Consultee Comments for Planning Application 22/01785/PLF

Proposal: Conversion of existing agricultural building to two dwellings

Name: . Building Conservation

PROPOSED ROOF PLAN

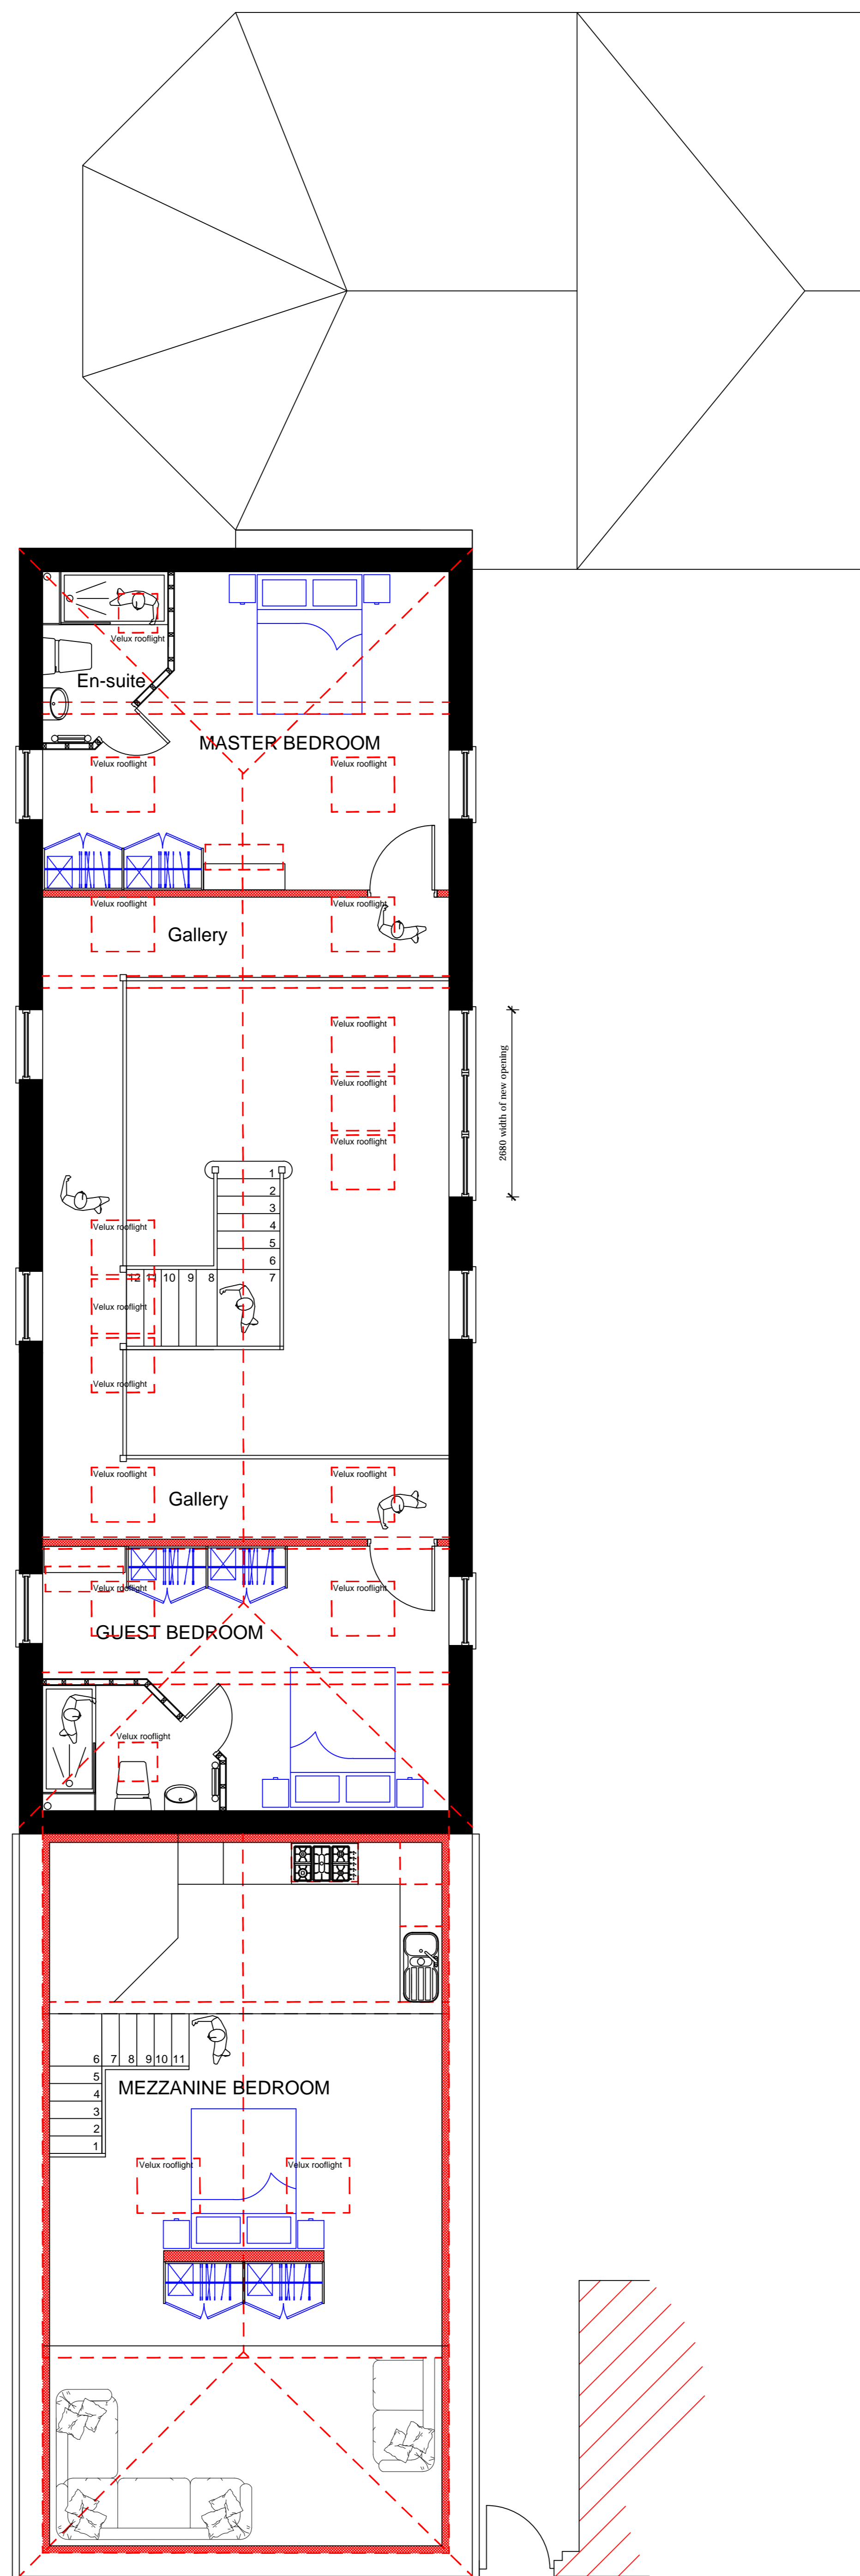
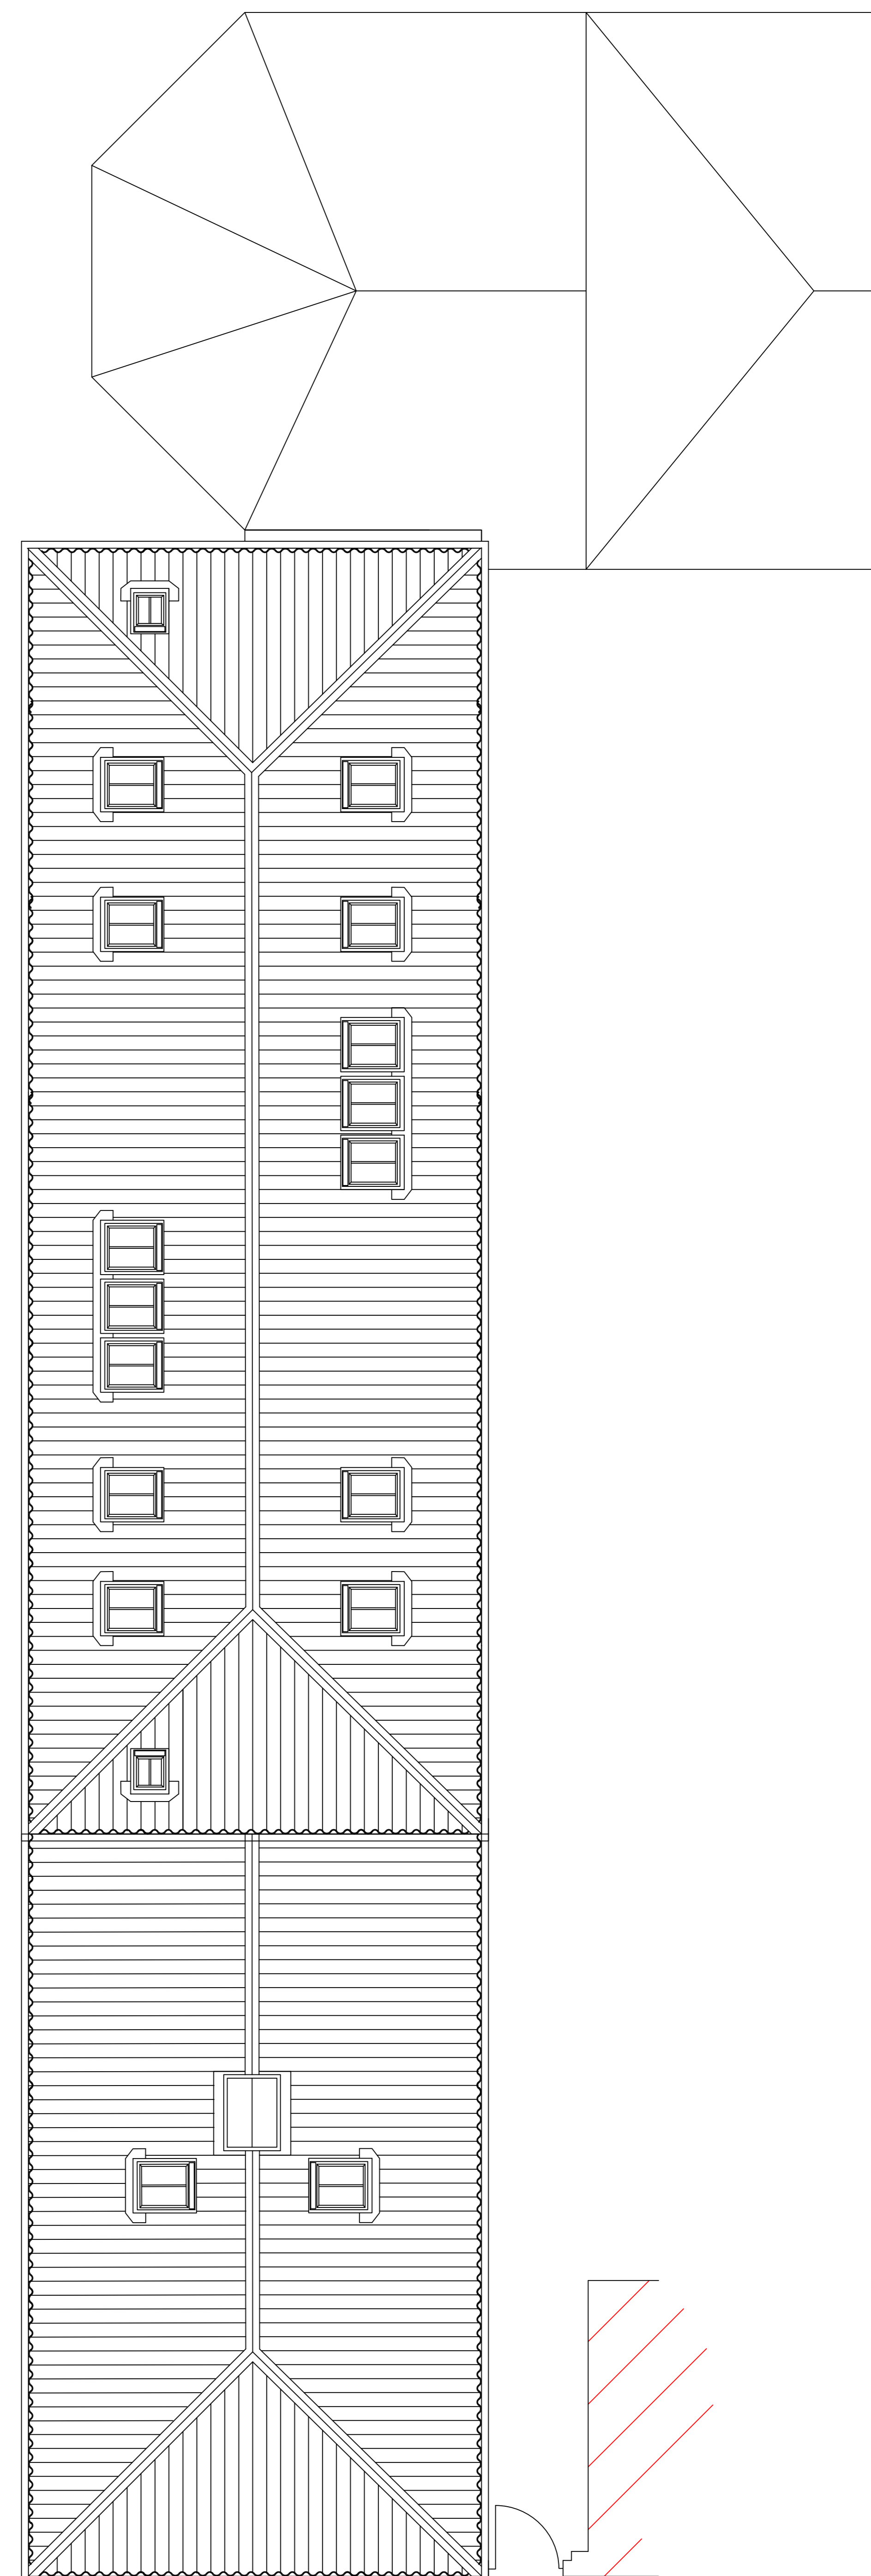
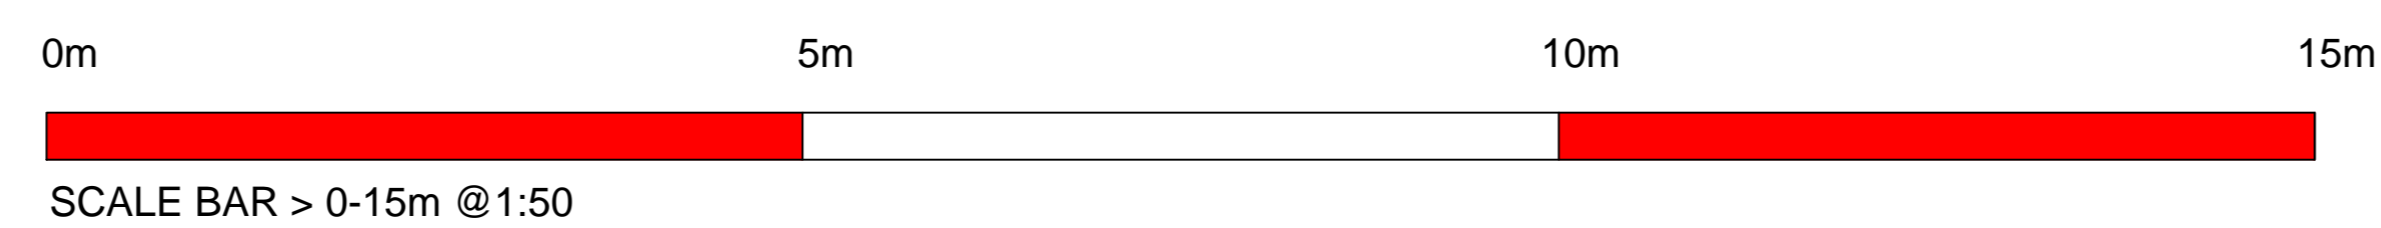
Whilst the no.3 large rooflights (on each roof elevation) have been reduced in size, it is noted that all rooflights have been increased in size to what was initially proposed. The three rooflights on each roof elevation above the large, glazed area have not been reduced in number as previously recommended, and so this combined with the three glazed windows below (now proposed to have glazing bars) still create a wall of glazing which as described previously, is not in keeping with the architectural or historical significance of the property.

We therefore recommend that the three proposed windows to the first floor is reduced in number to two, leaving a sensitive break between both. We also recommend reducing the number of rooflights above this area to one, so that visually the glazed wall would no longer impact the roof. We also recommend reducing all rooflights on each roof elevation to the smaller size initially proposed, rather than the medium sized rooflights proposed on the amended plans.

PROPOSED EAST ELEVATION

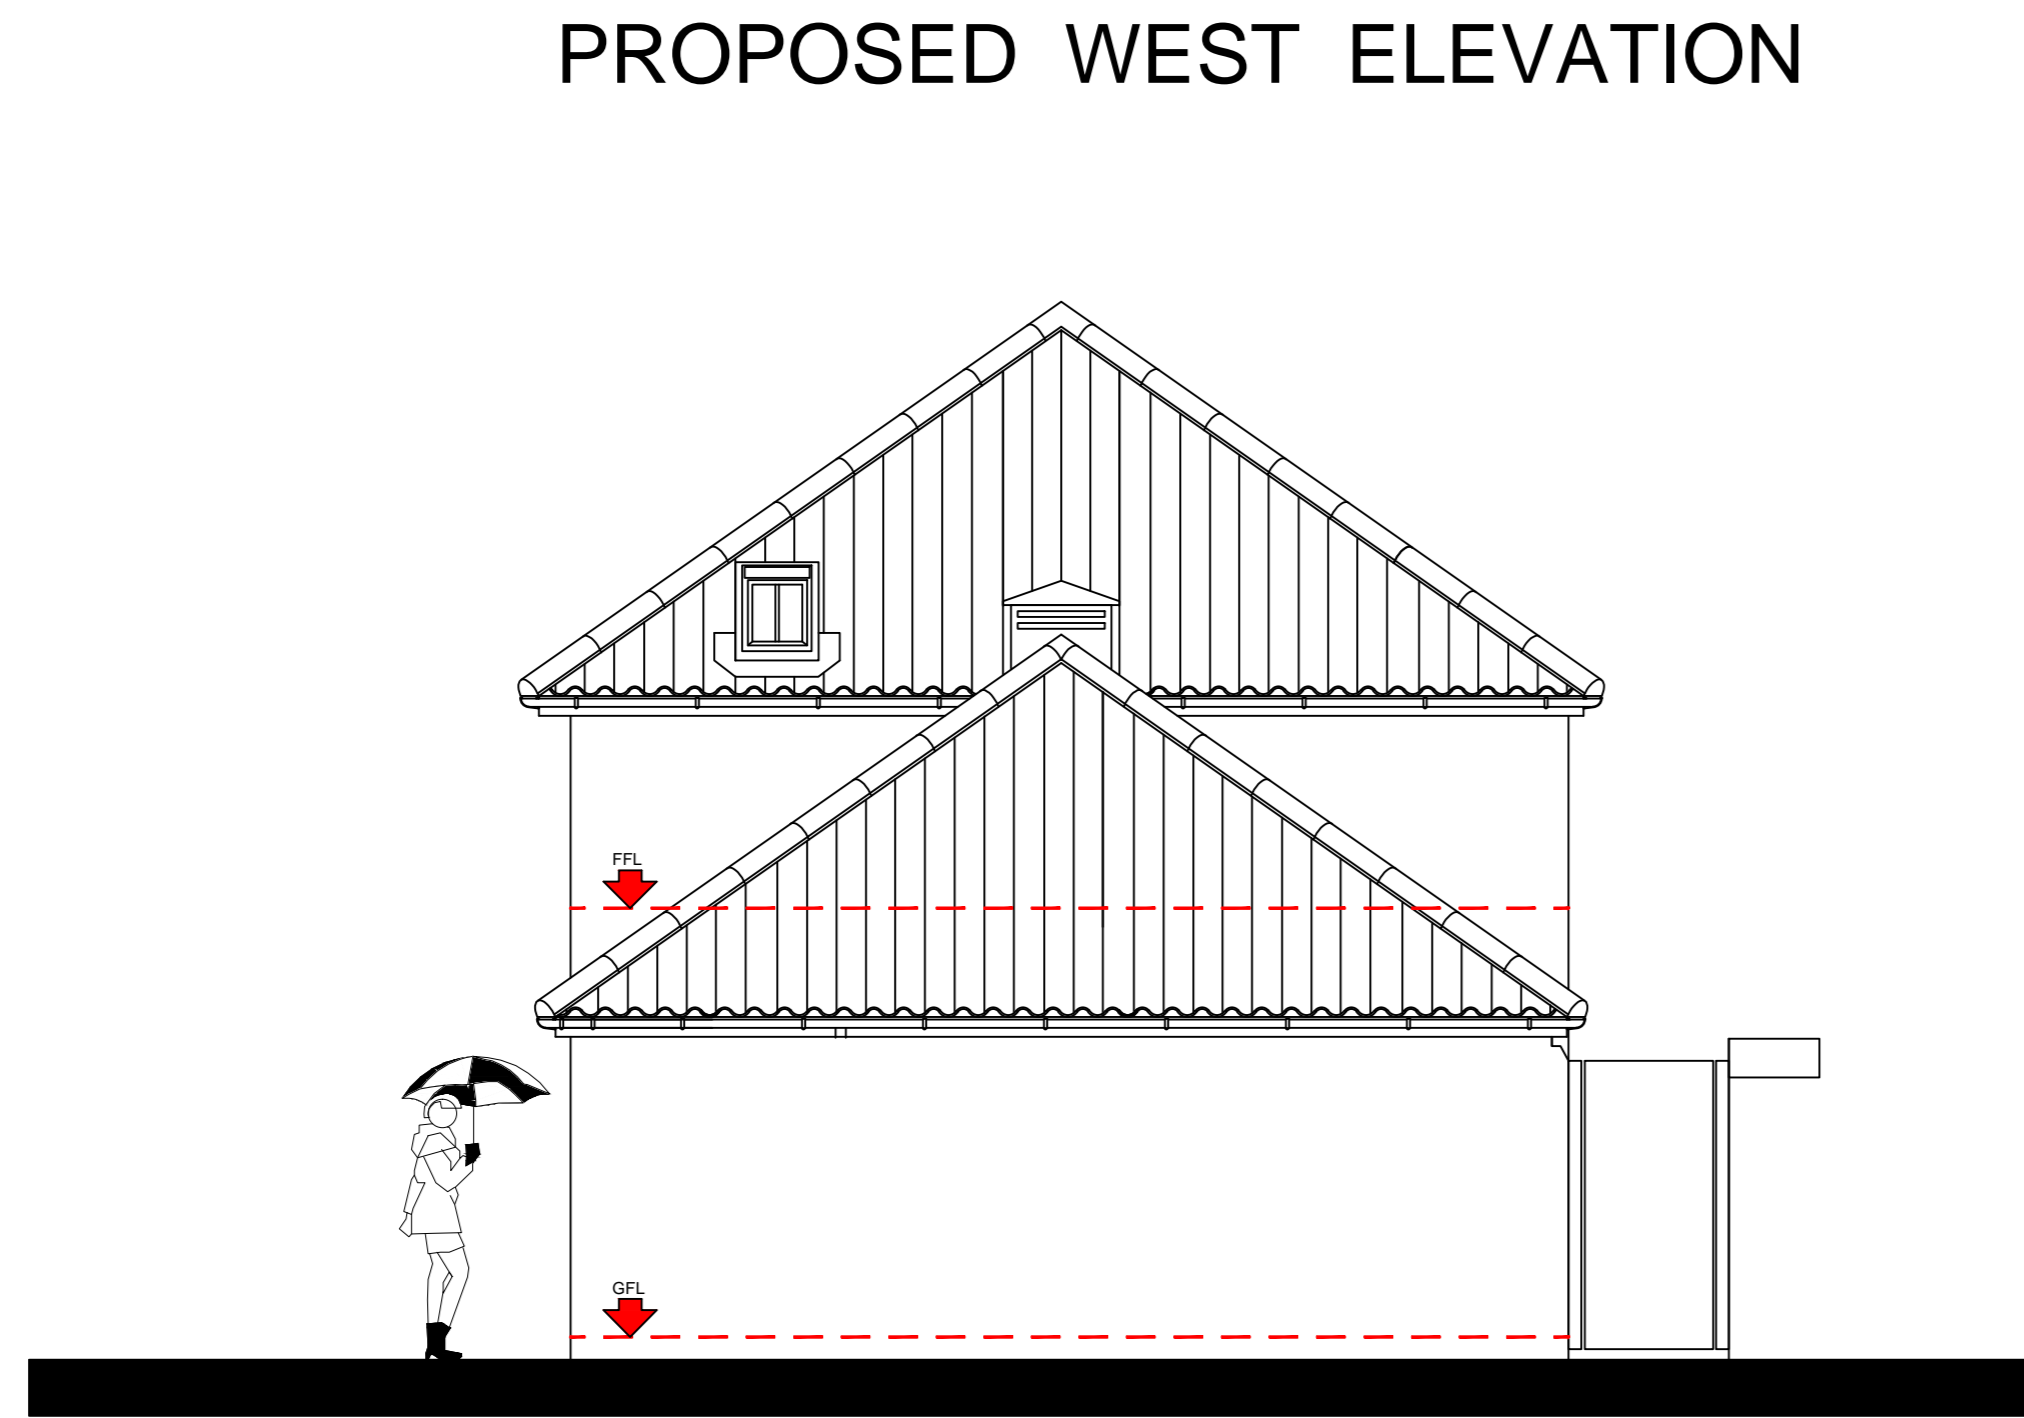
In previous comments, we recommended omitting the no.3 windows to the first floor of the east elevation, retaining one window (the opening currently exists) and we recommended reducing the no.6 large rooflights (three on each elevation) to match the size of others proposed as well as reducing the number from three to two. This was due to the concerns we had with the proposed quantity of glazing which created what visually appeared to be a wall of glazing. This element was assessed as being a visually intrusive feature out of keeping with the architectural and historical significance of the Grade II listed barn. Implementing our previous recommendations would have created a break in the wall of glazing proposed and would have allowed an existing window and materials to be retained.

The amended floor plan is supported, as is the omission of timber boarding below the windows on the far-left side of the east elevation.
